(Engineering comments by Jeff Rice)

**ISSUE RECORD**

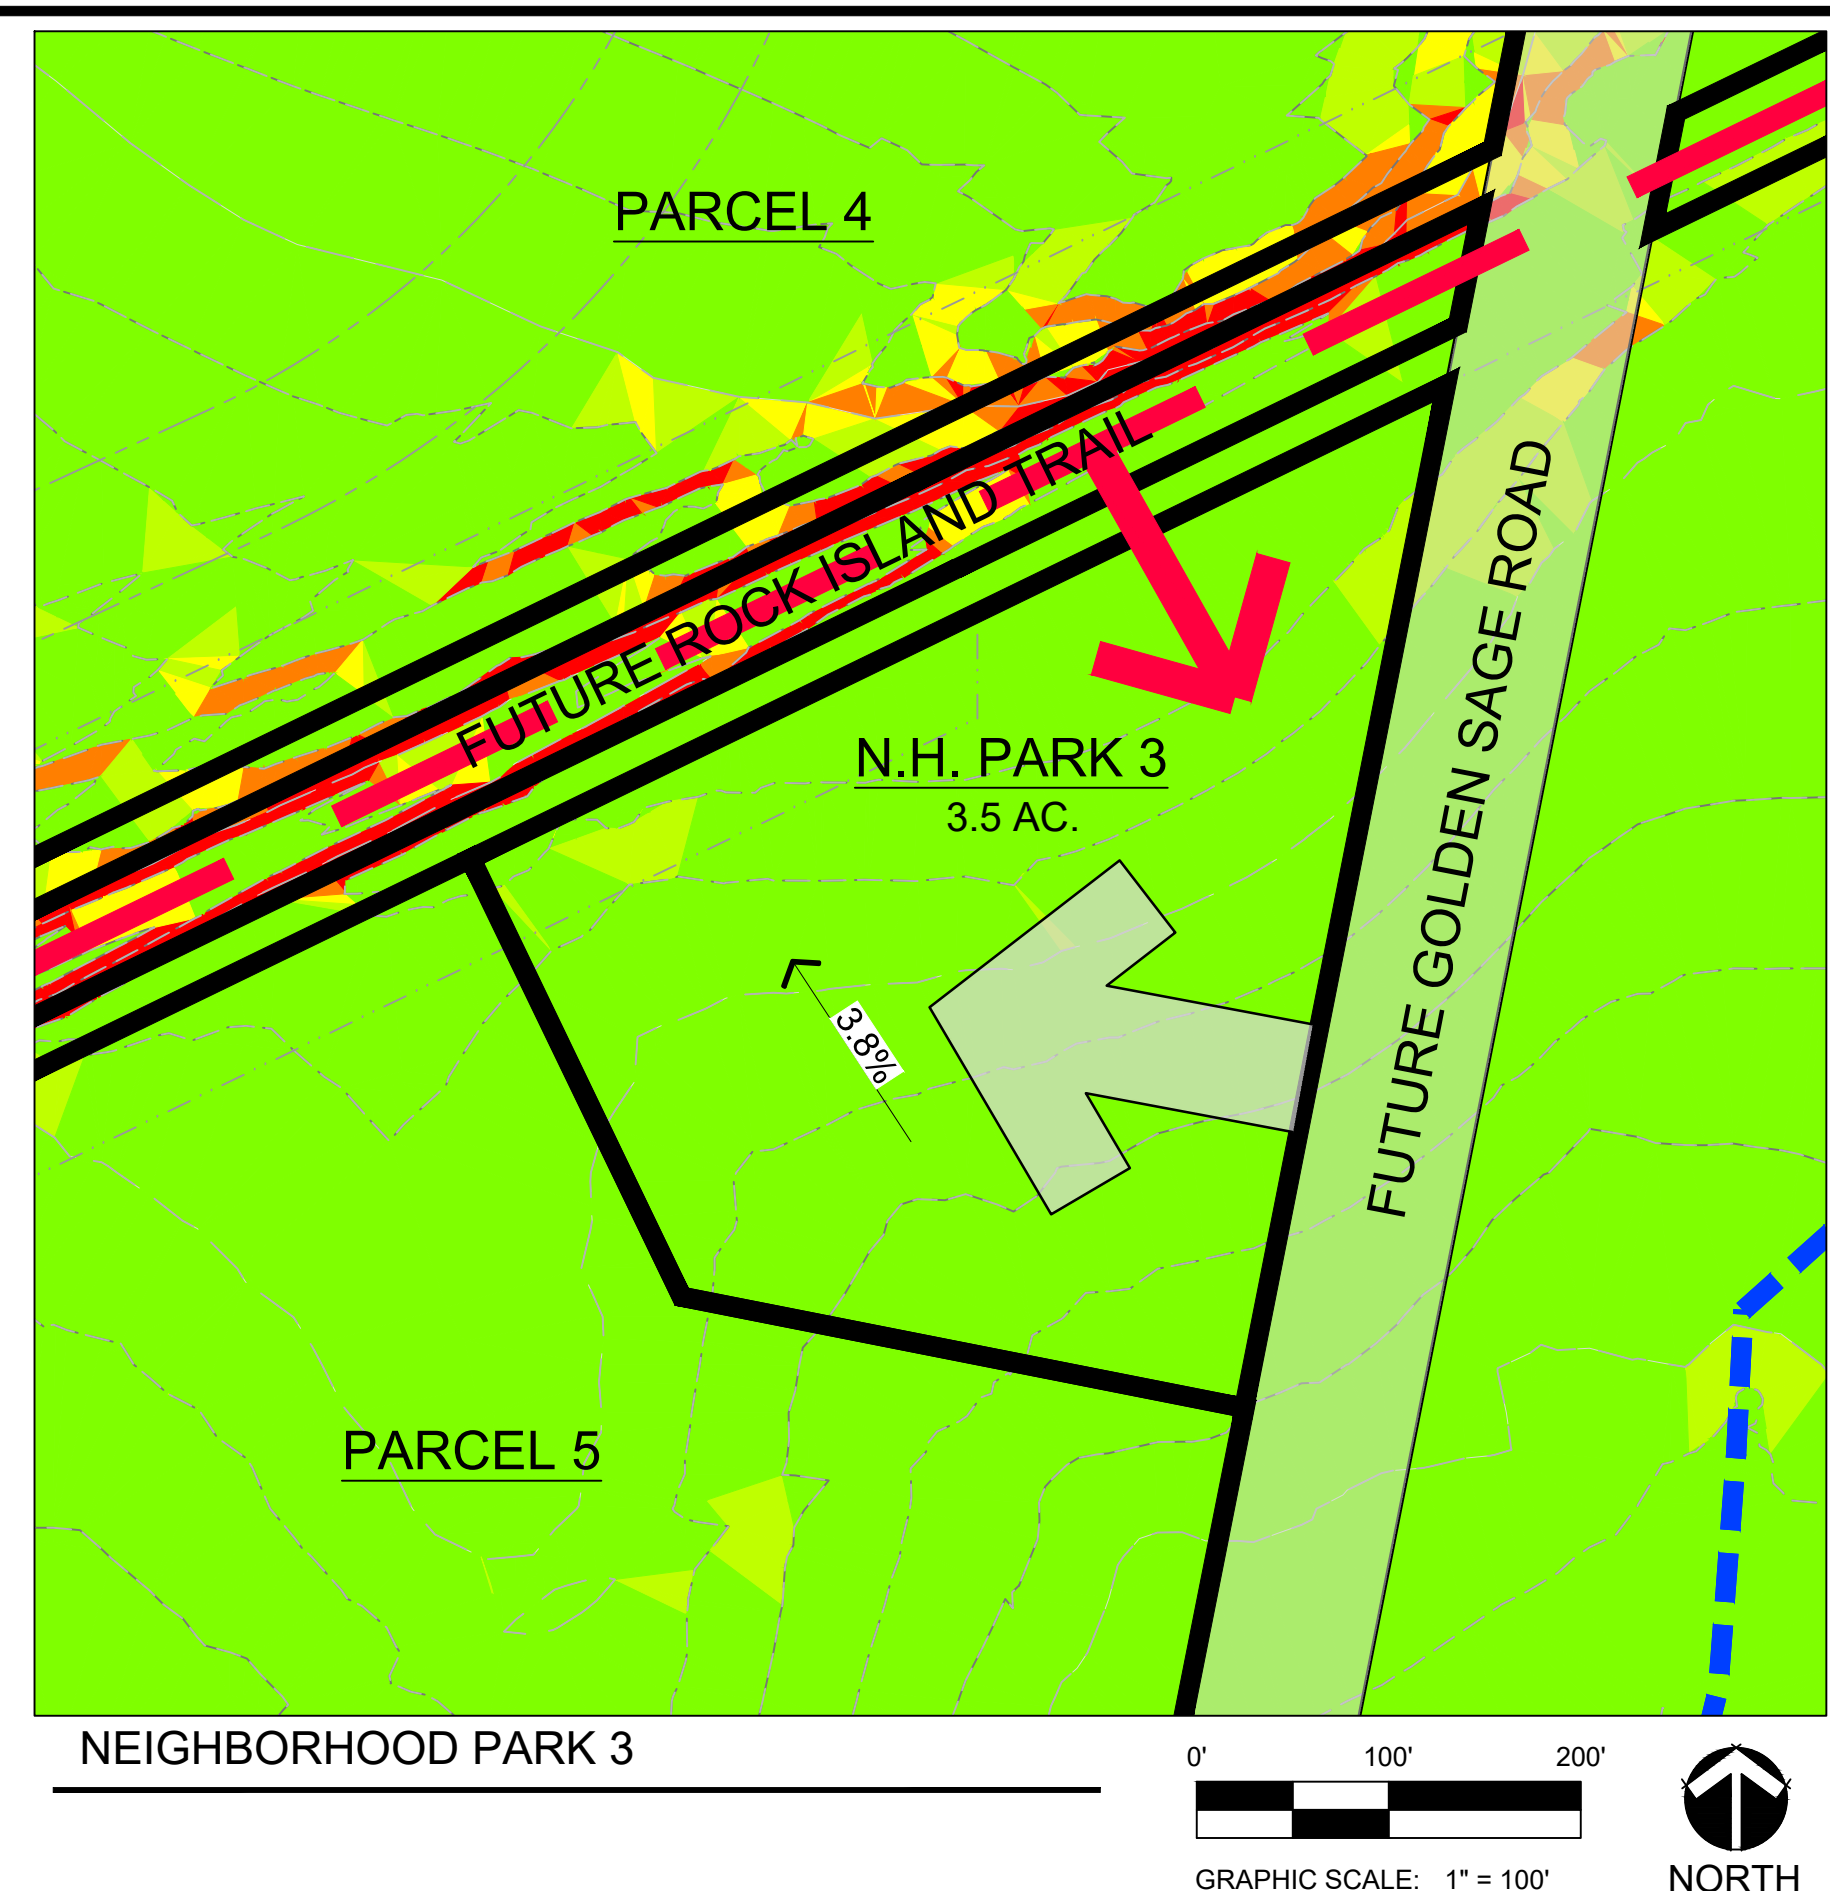
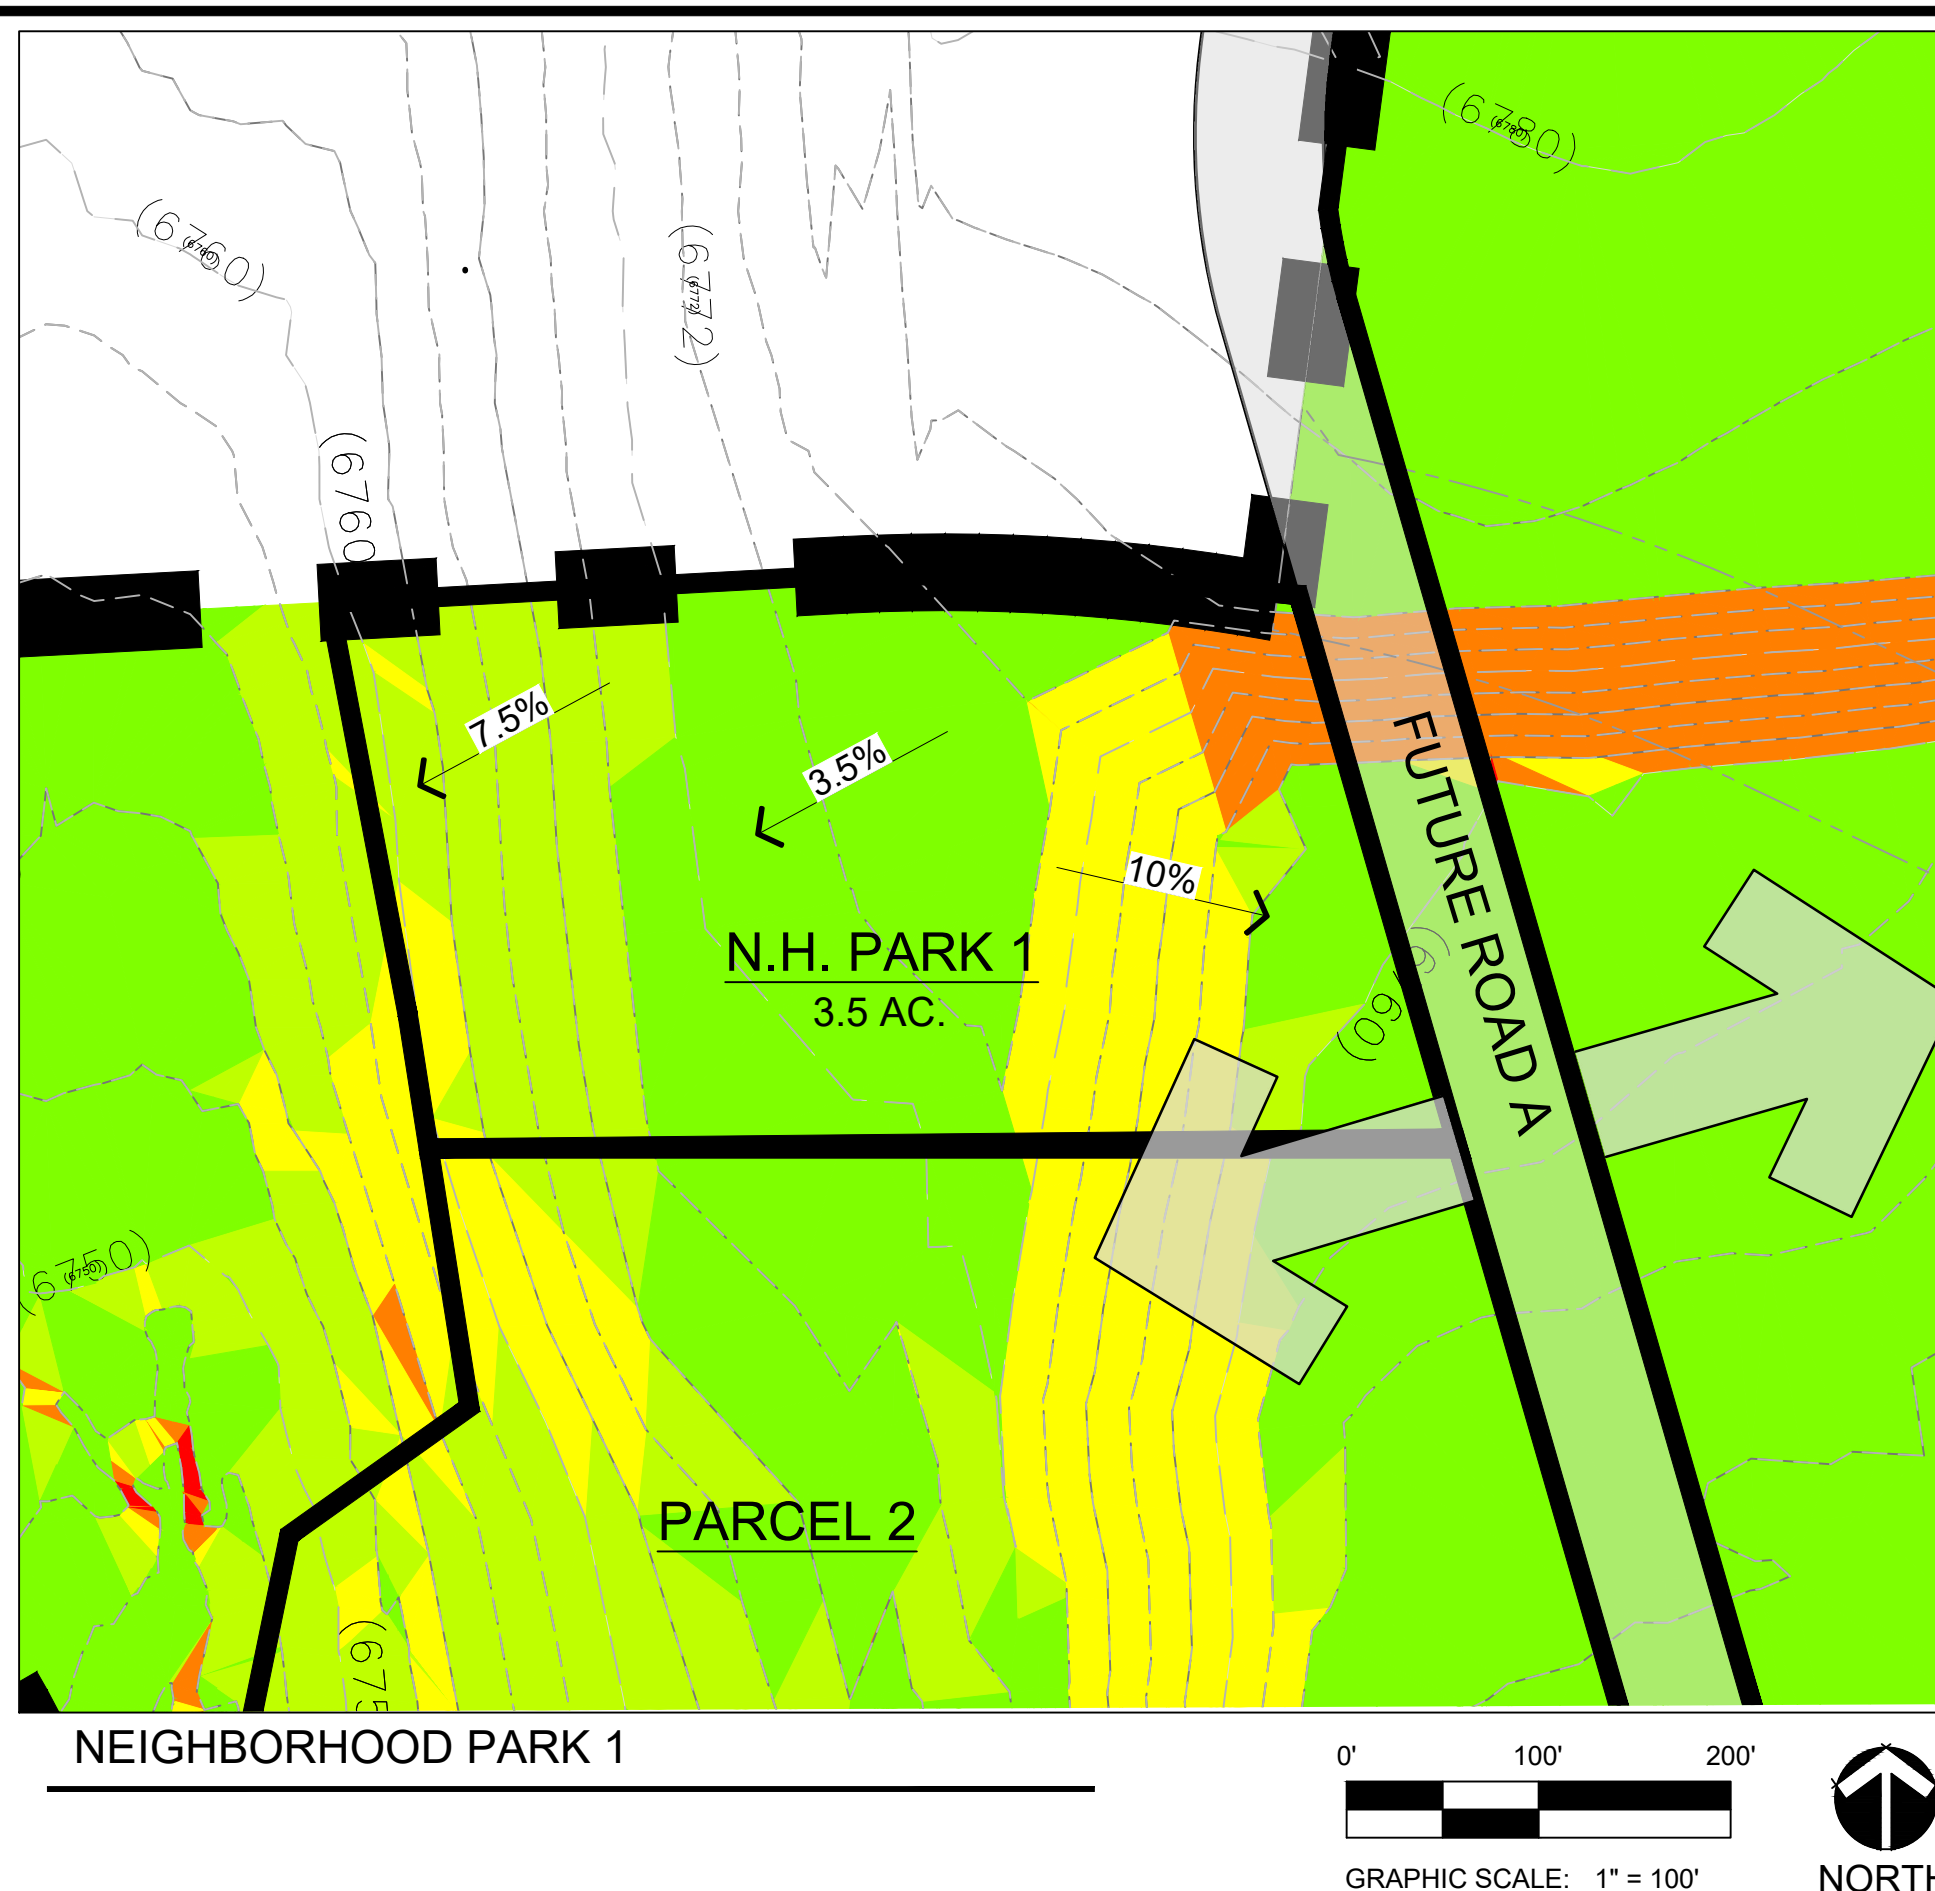
Why is ROW half of what is needed? (If Dublin is proposed to be split between incorporated and unincorporated areas, property acquisition from Falcon Highlands and EPC will be needed and County trail alignment (Rock Island and Falcon Hwy routes) in Tamlin Road ROW will need to be addressed.) (There was some coordination with Tim Roberts at the City in July 2022.)
